Engineers Comments Regarding Surface Water Drainage

Application Reference:	BN/76/26/DOC	Reviewer Reference:	ADC/EXT2/113
Planning Officer:	Amber Willard	Date of Review:	30/07/2026
Site Name:	Land South Of Wandleys Lane Eastergate PO20 3SE		
Application Description:	Approval of details reserved by condition under BN/46/25/PL relating to conditions 4- Surface Water Drainage and 9- Maintenance & Management of Sustainable Drainage Scheme.		
Assessment Number:	1

Response	Condition 4: Further information required Condition 9: Further information required
-----------------	---

Type D - 600 IC Non-entry
Inspection Chamber

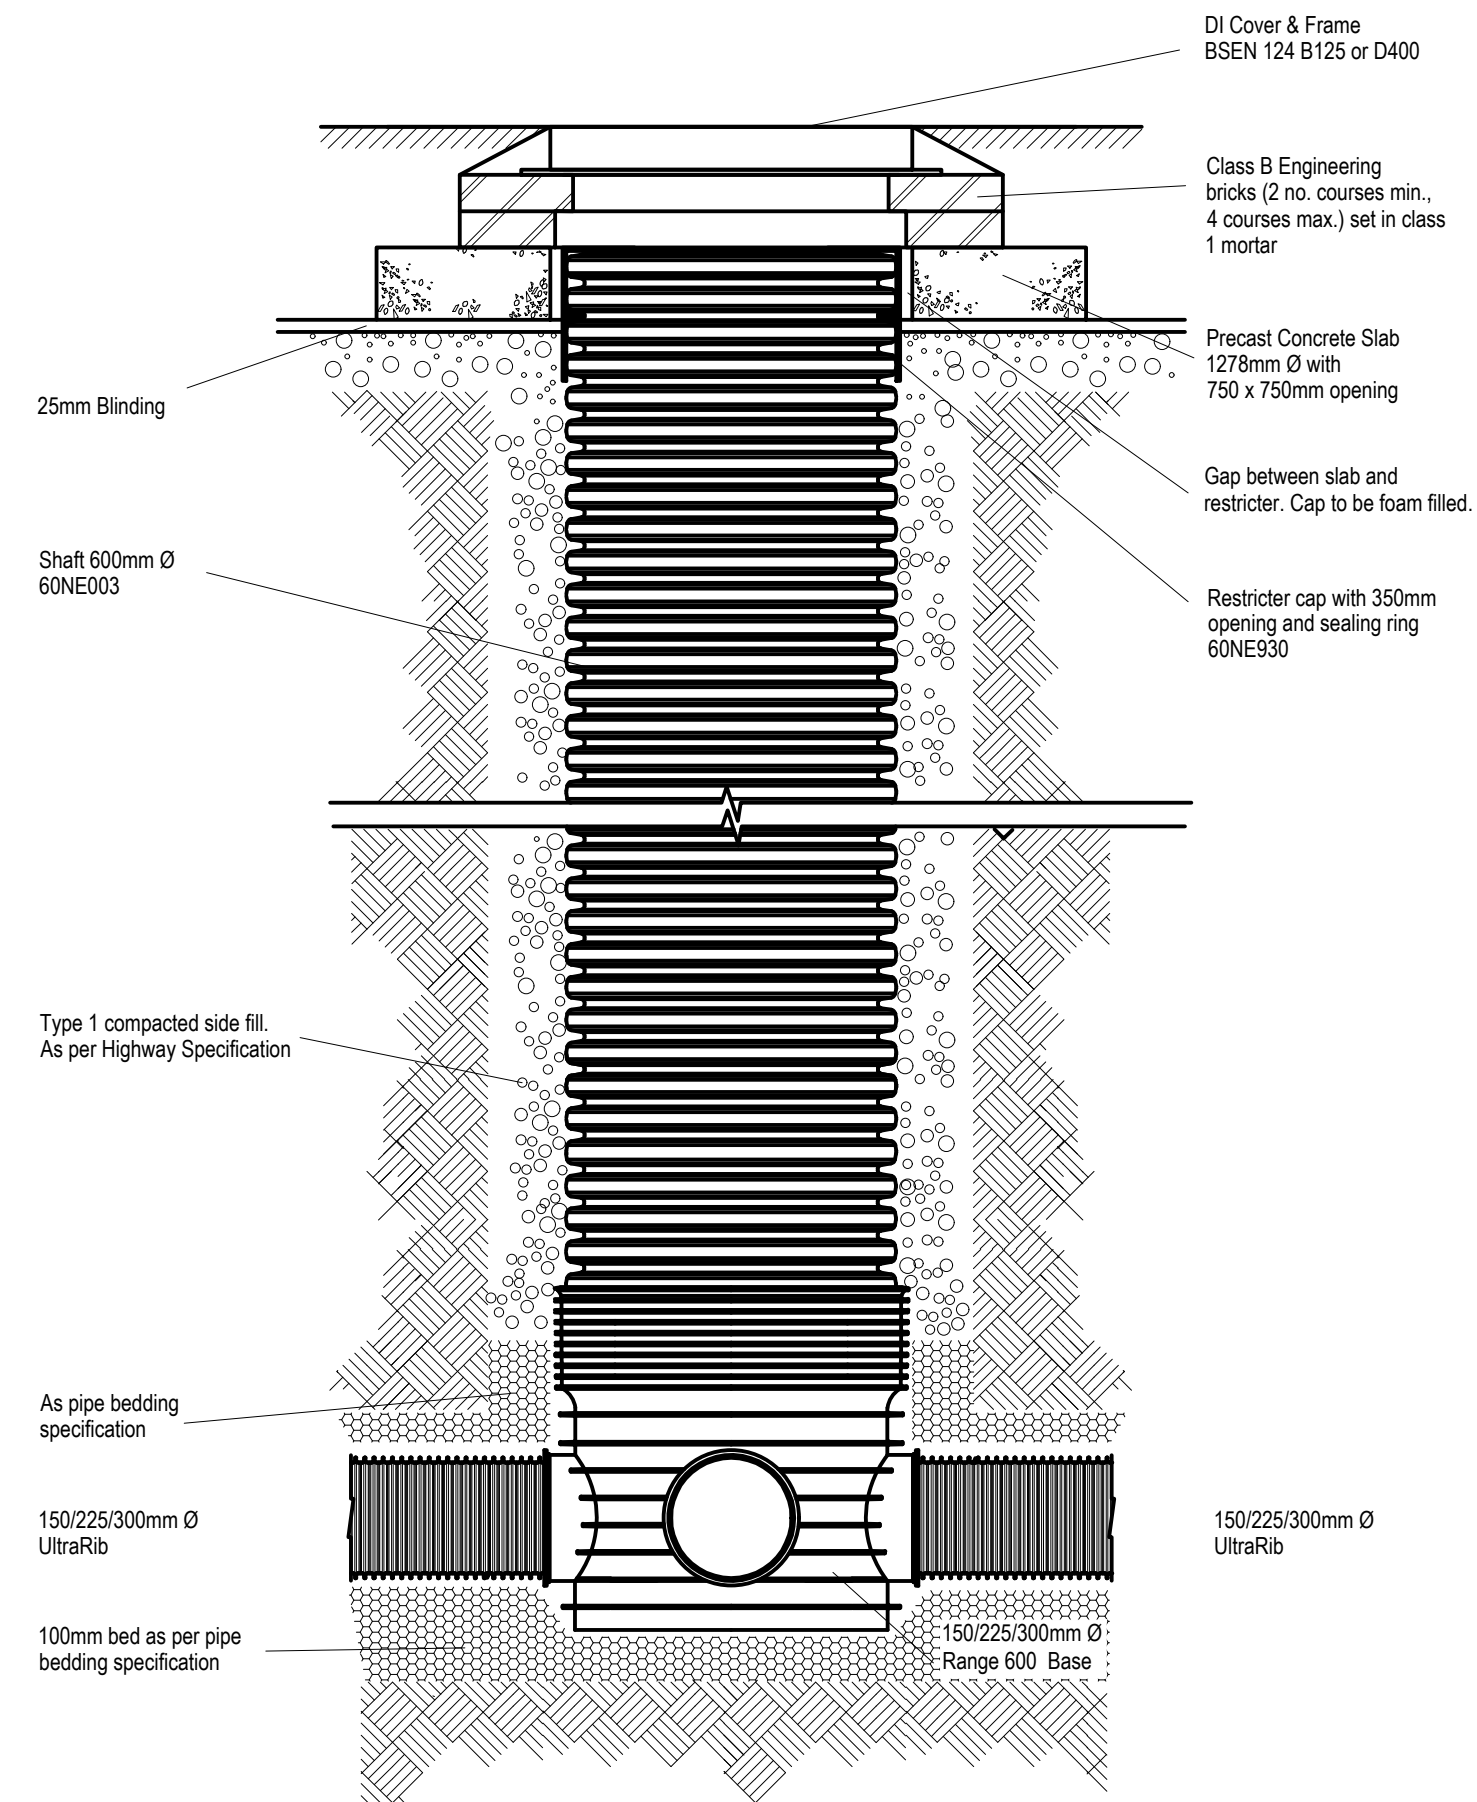
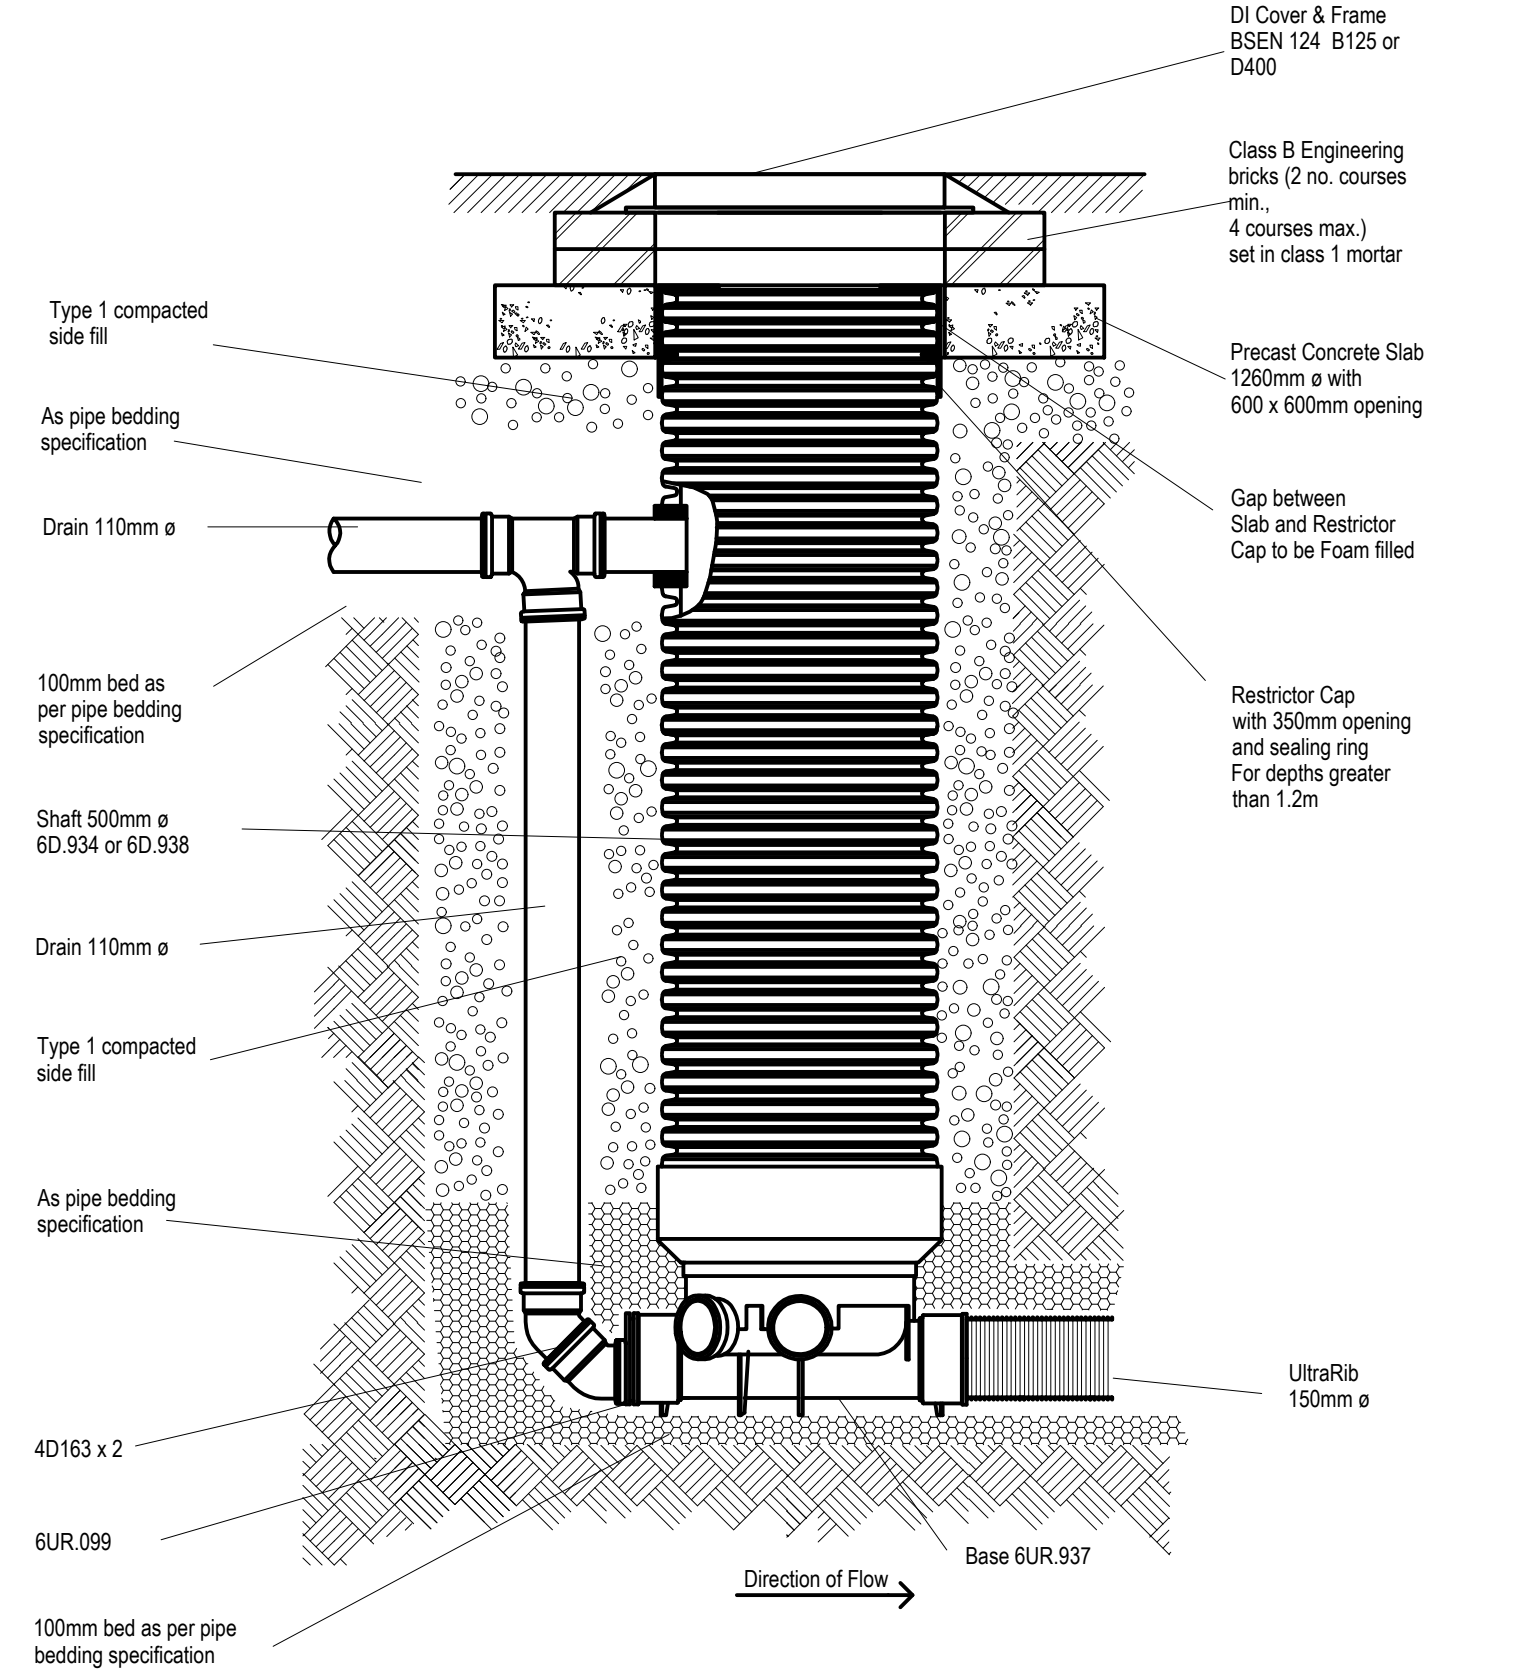
i.e. CBR's or pipe bedding requirements etc.	to be located at least 5m from a dwelling Soakaway rule).			
		Comment outstanding.			
29.	Inspection chamber types have been added to the construction details. Please refer to drg no. 476988-912_P03 – Construction Details-- Sheet 2.	Noted. Comment closed.

RAIN GARDEN
scale: 1/10

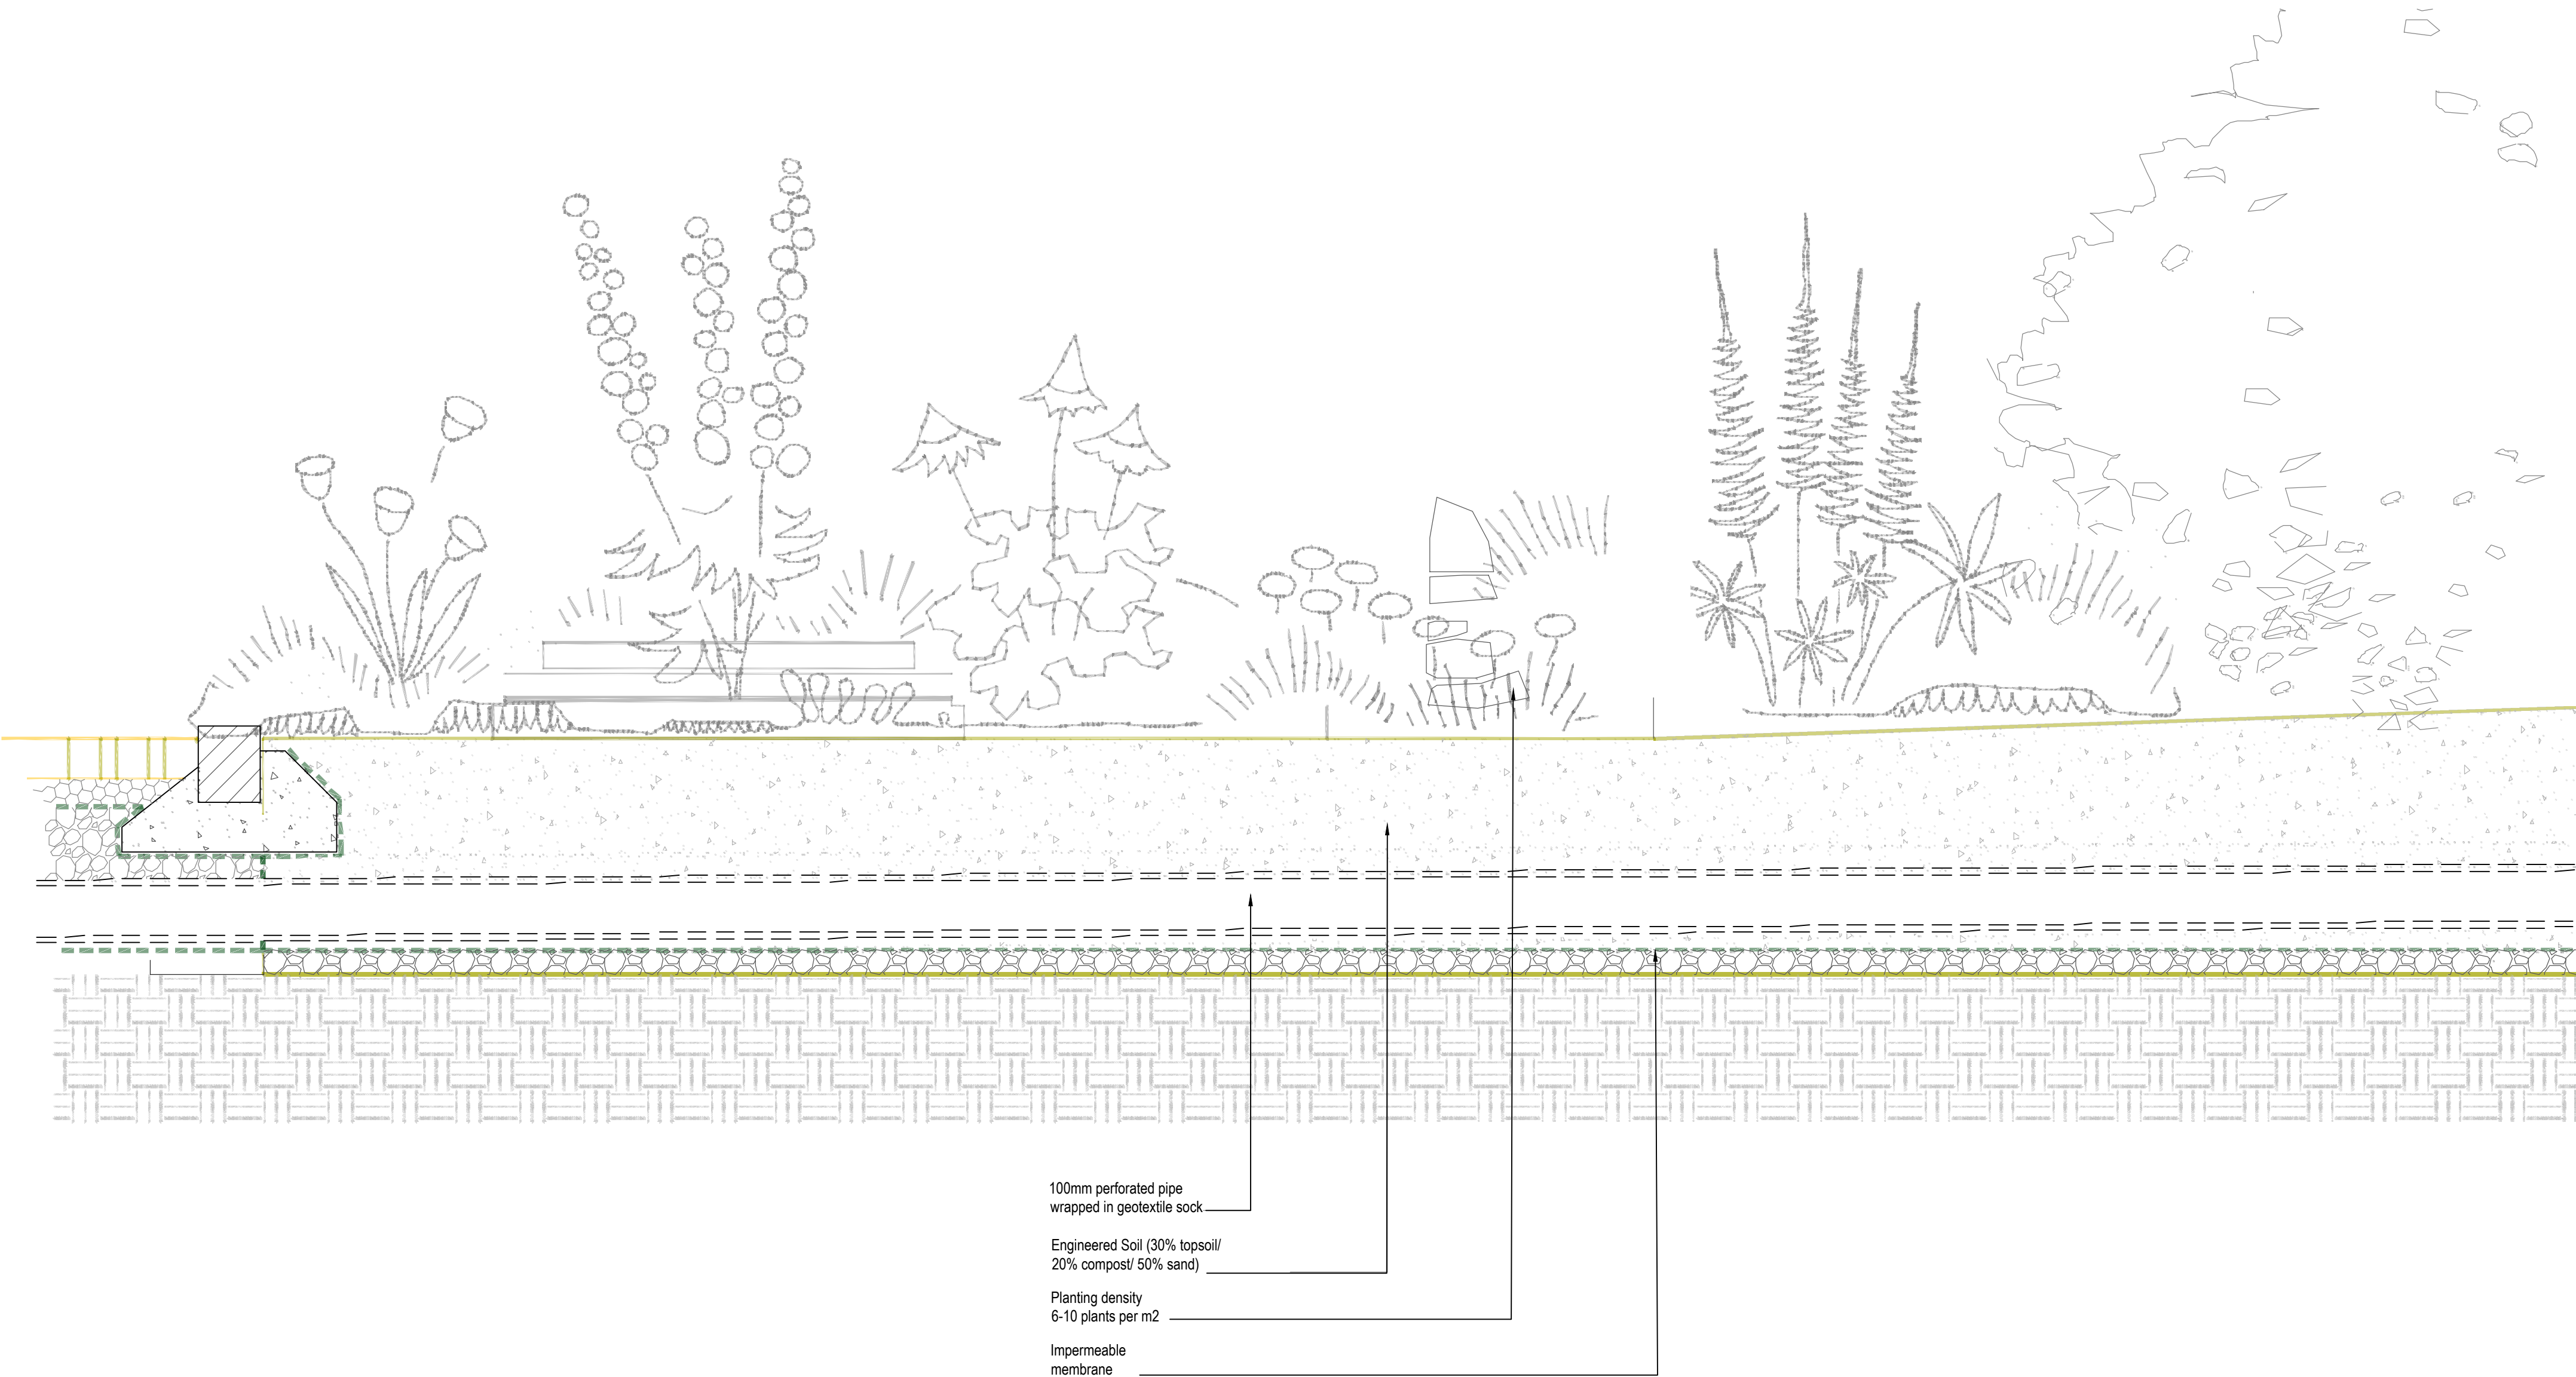
25.	The previous planning indicative landscaping information has been removed and replaced with the current more detailed landscaping designs.	Noted, however the current landscaping design was not supplied. It is assume this will also be coordinated with the raingardens. Comment outstanding.
